# **SCOPING OPINION:**

## **Proposed Shepway Energy Park**

**Case Reference: EN0110017**

**10 July 2025**

Figure 9-1g

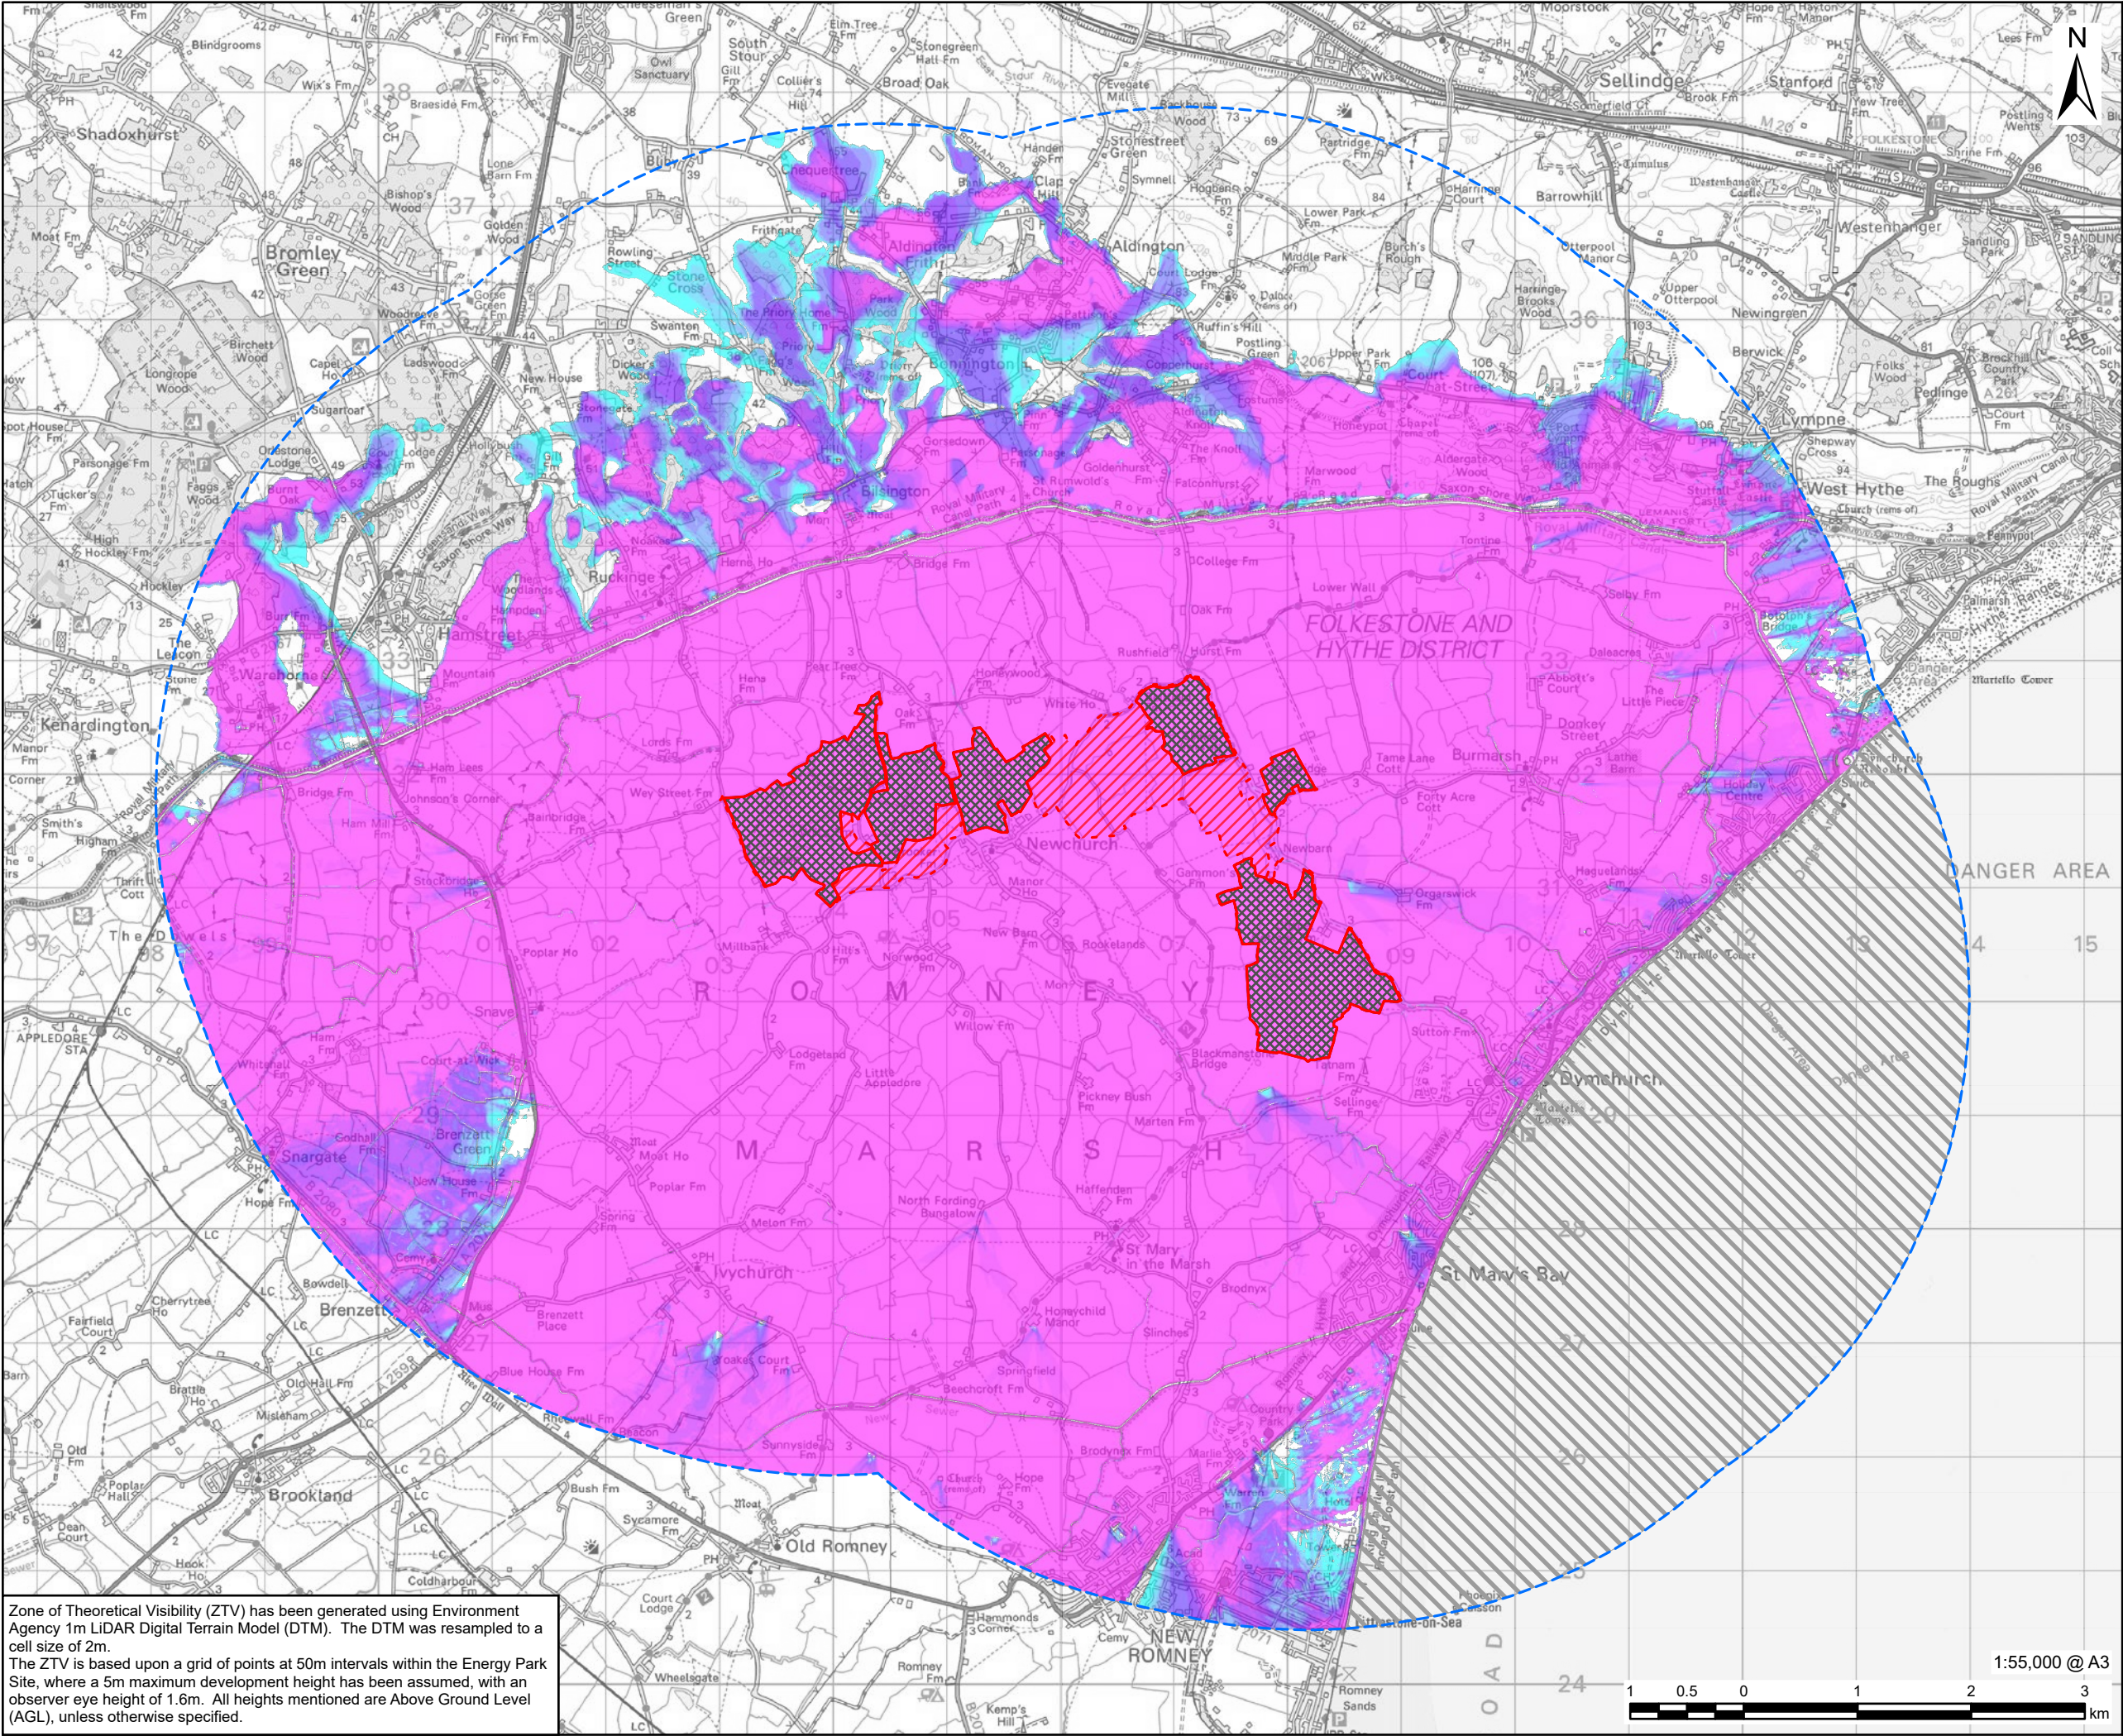
ID	Ref	Description	Inspectorate's comments
333	Paragraphs 9.2.1 -9.2.10 Figures 9.1a-h	Study area – Zones of Theoretical Visibility (ZTV)	<p>The Scoping Report states that a 5km LVIA study area is considered appropriate for the Energy Park Site although the extent of the full LVIA study area is to be reviewed throughout the iterative design process, subsequent ZTV production and further fieldwork.</p> <p>The Inspectorate considers that the study area should be informed by the extent of likely effects rather than an arbitrary study area boundary.</p> <p>The ES should justify the extent of the study area with reference to recognised professional guidance and the extent of the likely impacts, informed by fieldwork and relevant models or approaches such as the ZTV.</p>
334	Paragraph 9.2.7	LVIA Study Area for the Interconnecting Cable Corridors and the Grid Connection Route	<p>The Scoping Report states that the LVIA study area for the interconnecting cable corridors and the grid connection route would reflect the temporary nature of impacts likely to arise for these elements, with no permanent above-ground structures, and the Applicant does not anticipate that ZTVs would be provided for these elements and the study area, which would be refined once the extents are defined, will be proportionate to the expected effects.</p> <p>The Inspectorate considers that the ES should evidence how the study area has been derived to ensure it is representative of the project's effects and should be agreed with relevant consultation bodies where possible.</p>

**Figure 9-2: Proposed LVIA Viewpoint Locations**

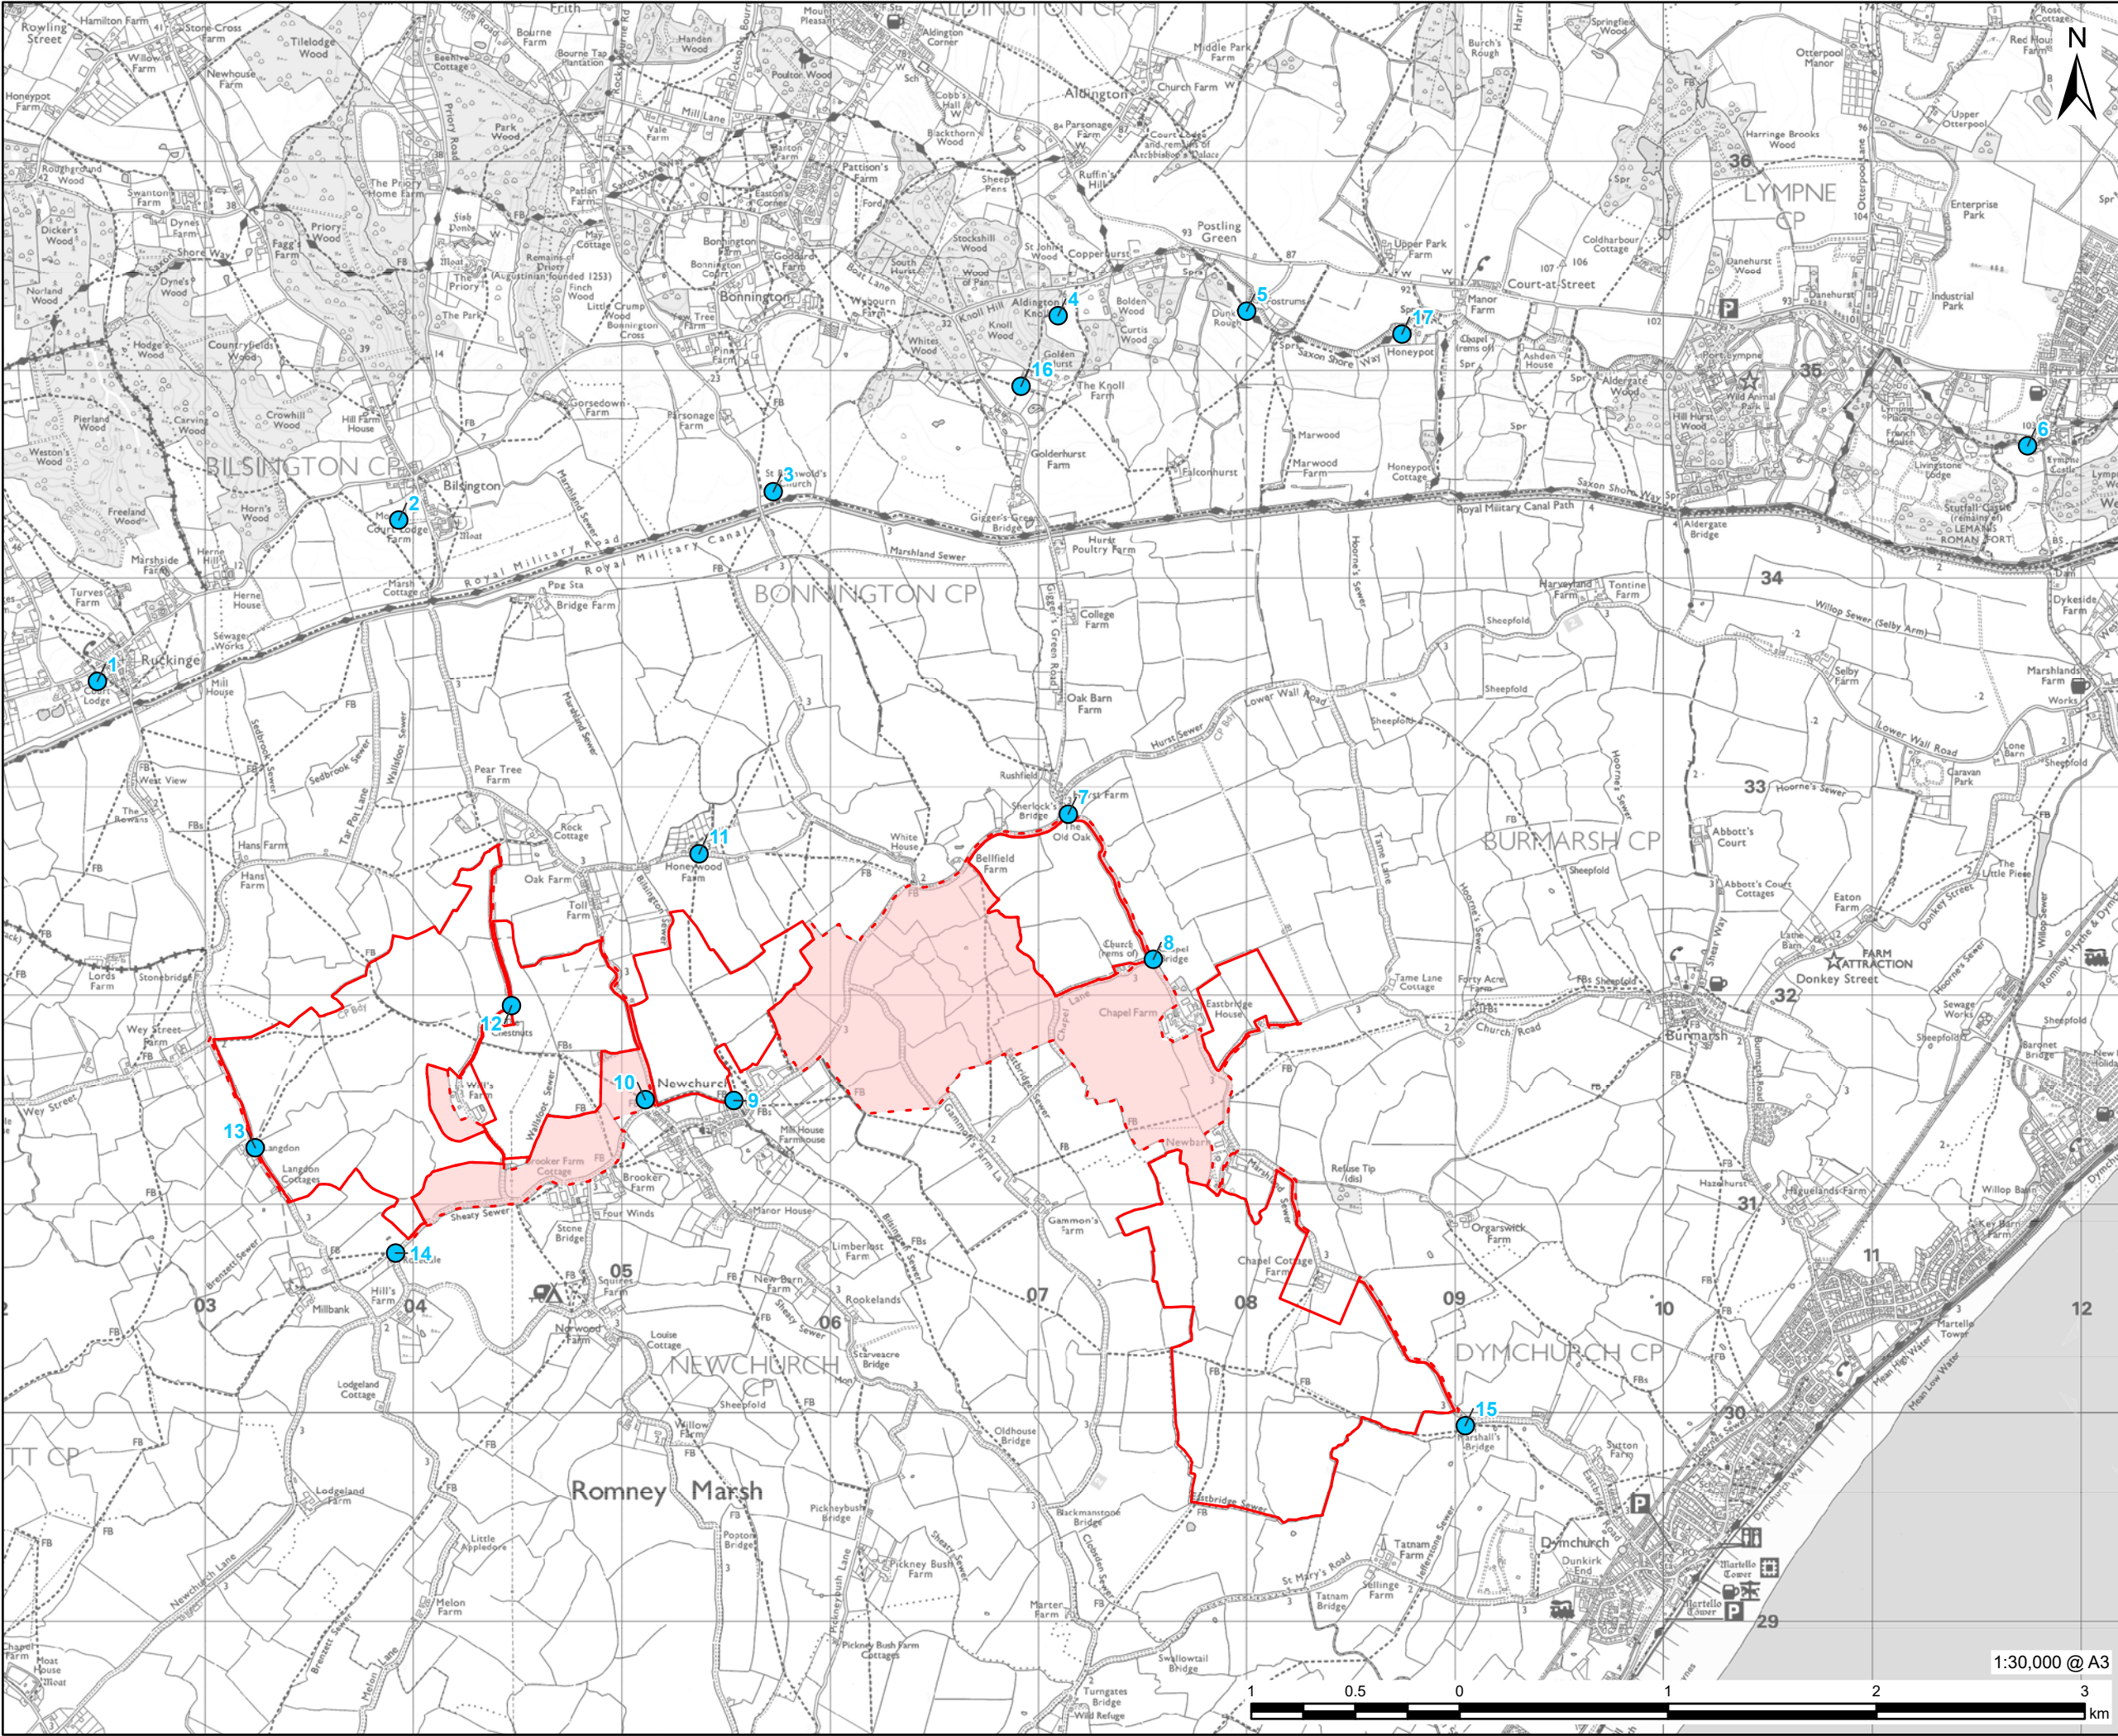
ID	Ref	Description	Inspectorate's comments
335	Paragraphs 9.5.44 and 9.5.45 Figure 9-2	LVIA viewpoints	<p>The ES should explain how the number of viewpoints for the LVIA have been chosen and explain how these are representative. Viewpoints should be consulted on and where possible agreed with relevant consultation bodies.</p> <p>The Applicant's attention is directed to the comments of Natural England, Ashford Borough Council and Folkestone and Hythe District Council on this matter included in Appendix 2 of the Scoping Opinion.</p>
336	Paragraphs 9.5.46 and 9.5.47	Visualisations and photomontages	<p>The assessment should be supported by appropriate visualisations such as photomontages to help illustrate the likely impacts of the proposed development and should be based on the latest best practice guidance from the Landscape Institute.</p> <p>Effort should be made to agree the assessment approach, sensitive receptors and appropriate viewpoint locations for visualisations with relevant consultation bodies.</p> <p>Photomontages and visualisations used to illustrate the landscape and visual effects of the proposed development should be provided for both winter and summer assessment periods to demonstrate the impact of any landscape mitigation proposed.</p> <p>The Applicant's attention is directed to Folkestone and Hythe District Council's comments on this matter included in their response in Appendix 2 of the Scoping Opinion.</p>
